**Re: Geotechnical Grading Plan Review – Proposed Highschool Orleans
Sud – 2405 & 2419 Mer Bleue Road, Ottawa, Ontario**
Cambium Reference: 20361-003 Rev.1

Project: Nouvelle École ESP Orleans-sud 2405 / 2419 rue Mer-Bleue, Drawing No. C301: "Grading and Drainage Plan", prepared by grc architects, dated September 9, 2025: Issued for Addenda.

**GRADING & DRAINAGE  
PLAN**

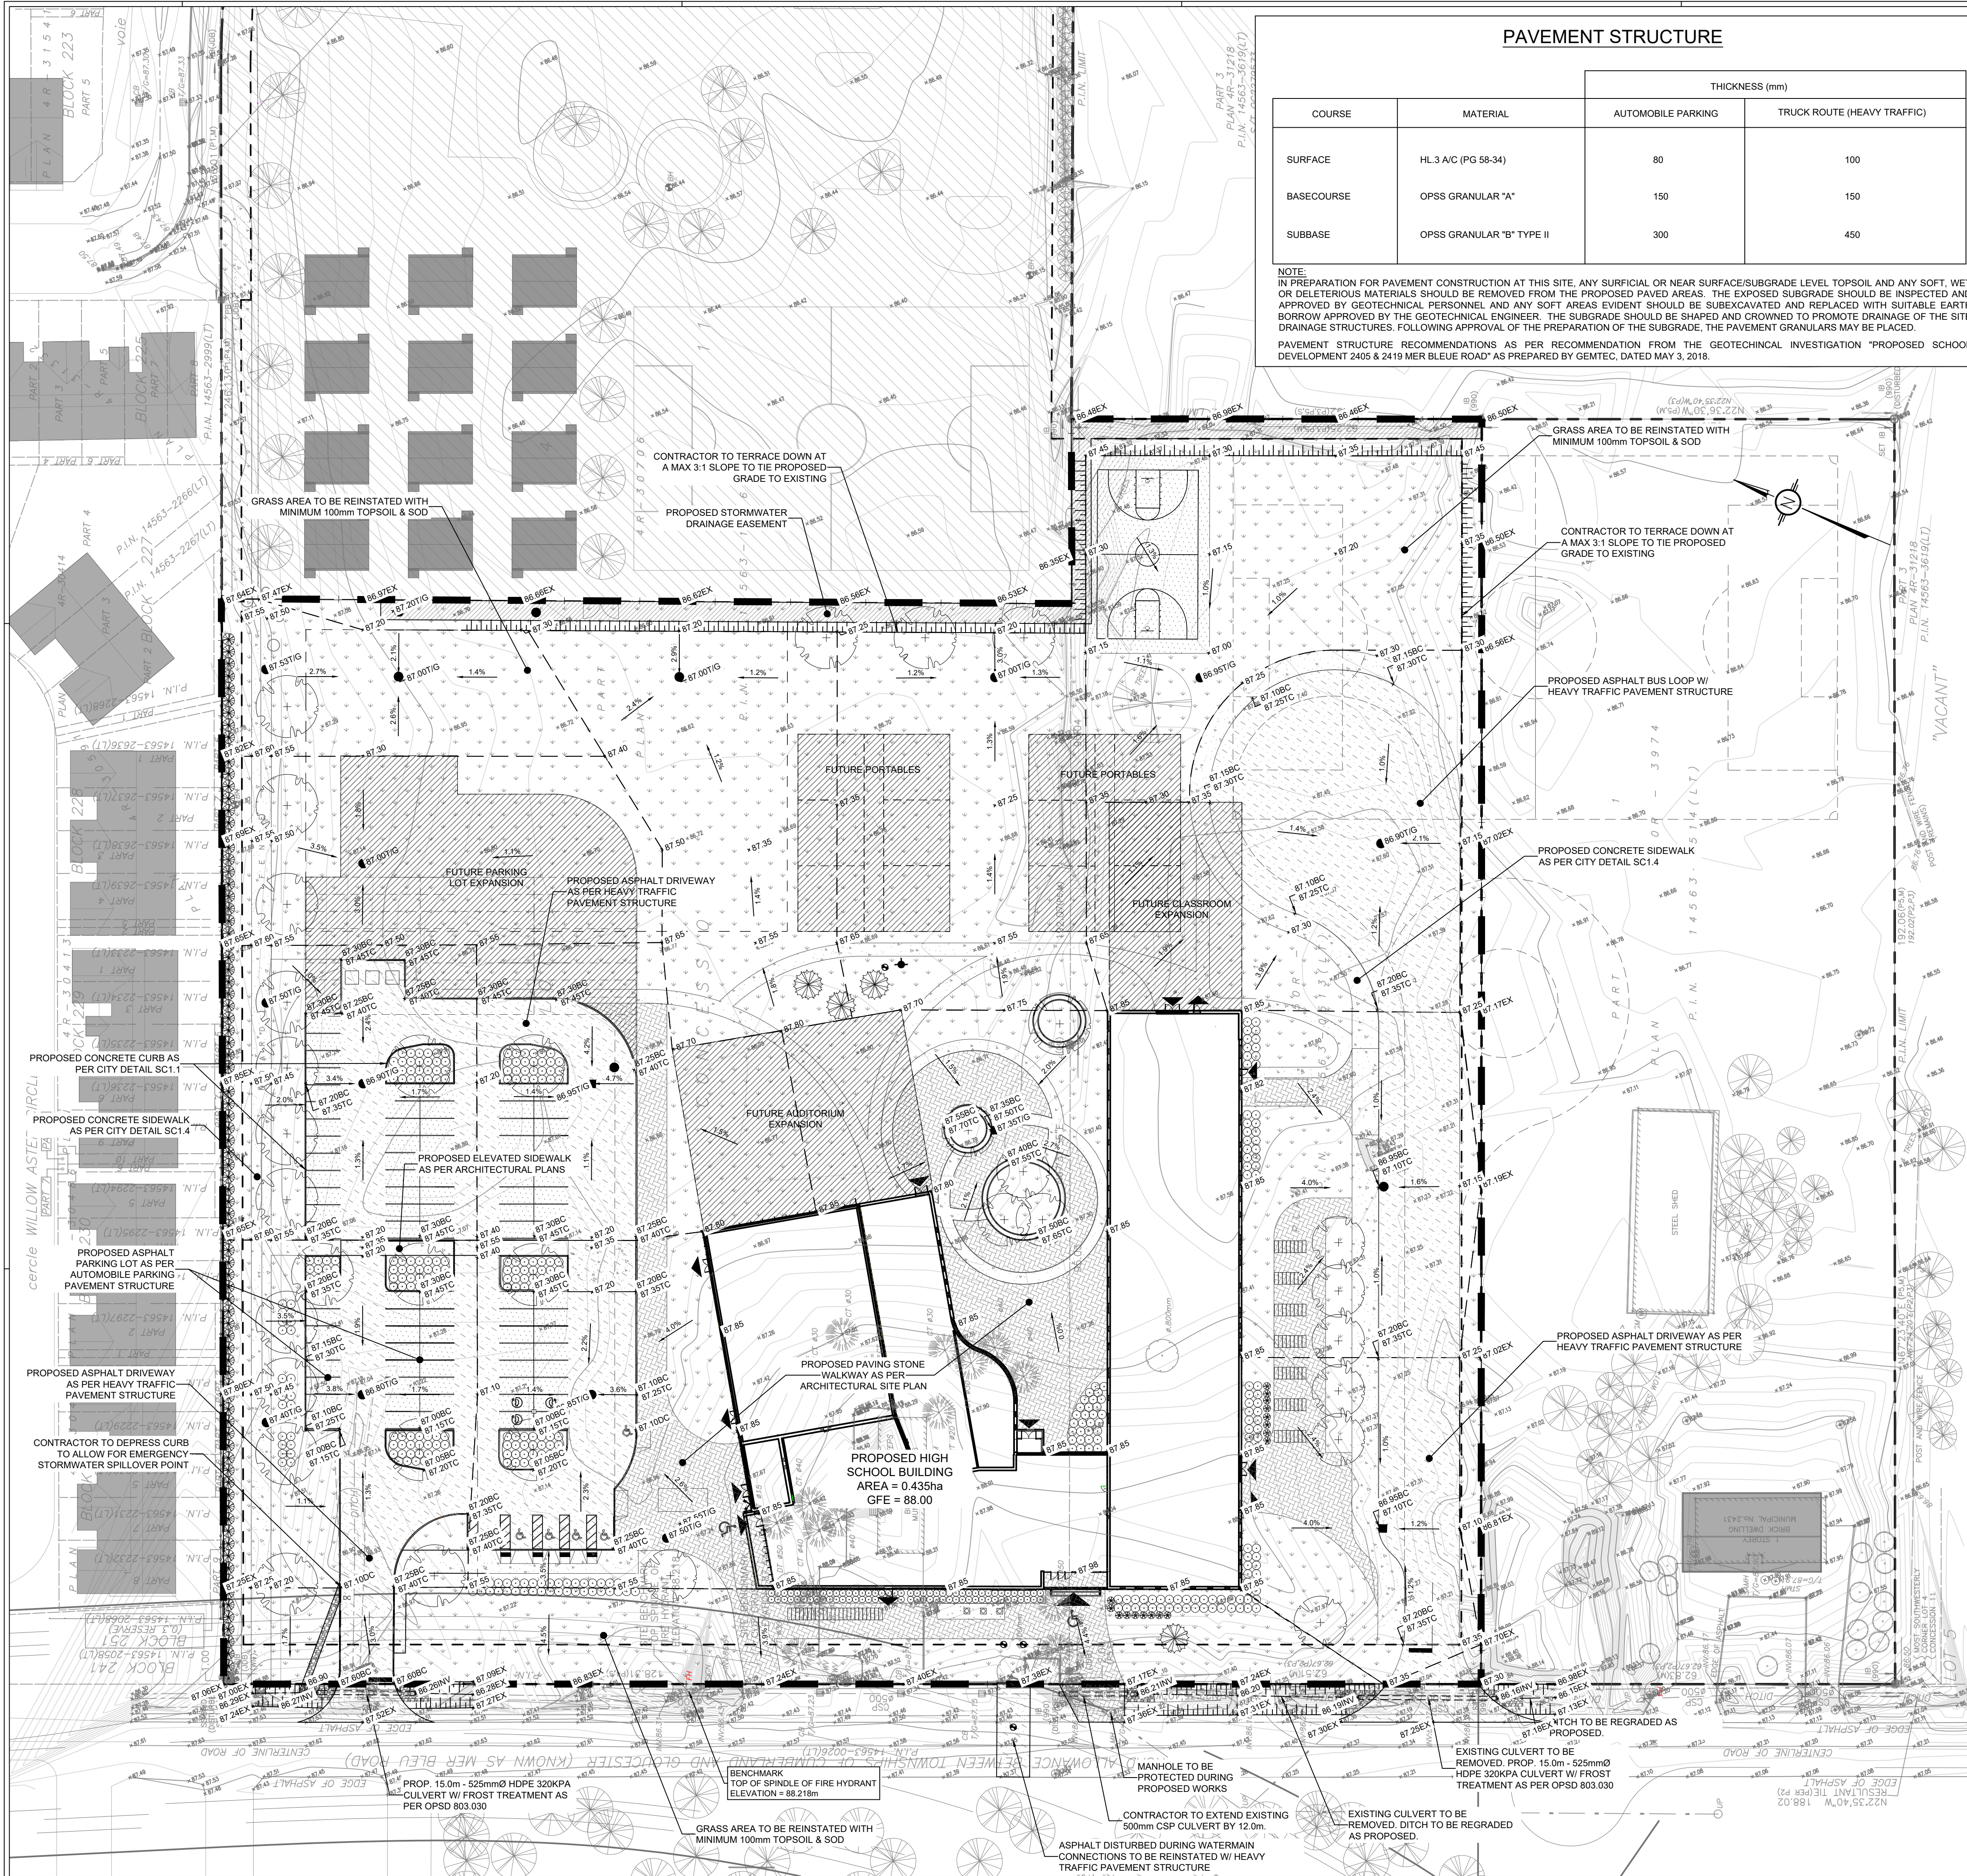
Based on the review, the site grades are within restriction tolerances outlined within the geotechnical report.

There is a noted exceedance within the parking area at one curb. However this was confirmed through correspondence with the Civil Engineer on September 22, 2025 (via email, Kyle Herold <kherold@lrl.ca>) that the exceedance is a typo. The proposed elevation of the curb was provided and within acceptable grade raise limits of the parking area. It is understood that the typo will be corrected in the next revision of the grading plan.
